EL PASO COUNTY STORMWATER MANAGEMENT PLAN CHECKLIST

Revised 5/21/07

Lot 1, Largent Subdivision

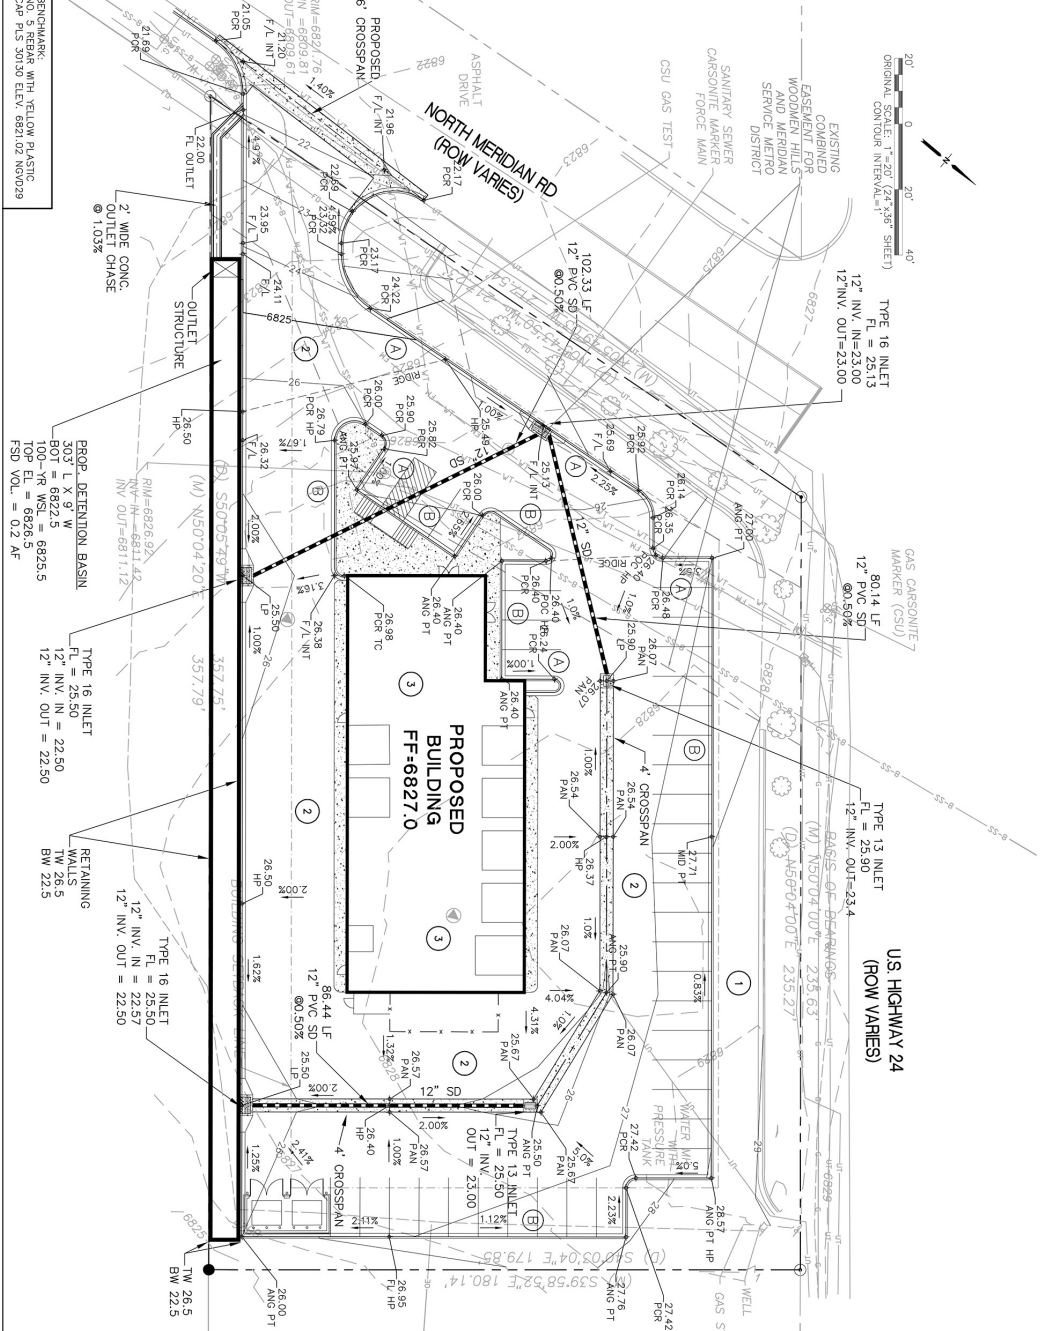
Unresolved 17) SWMP Map to include:

Include a copy in the Report
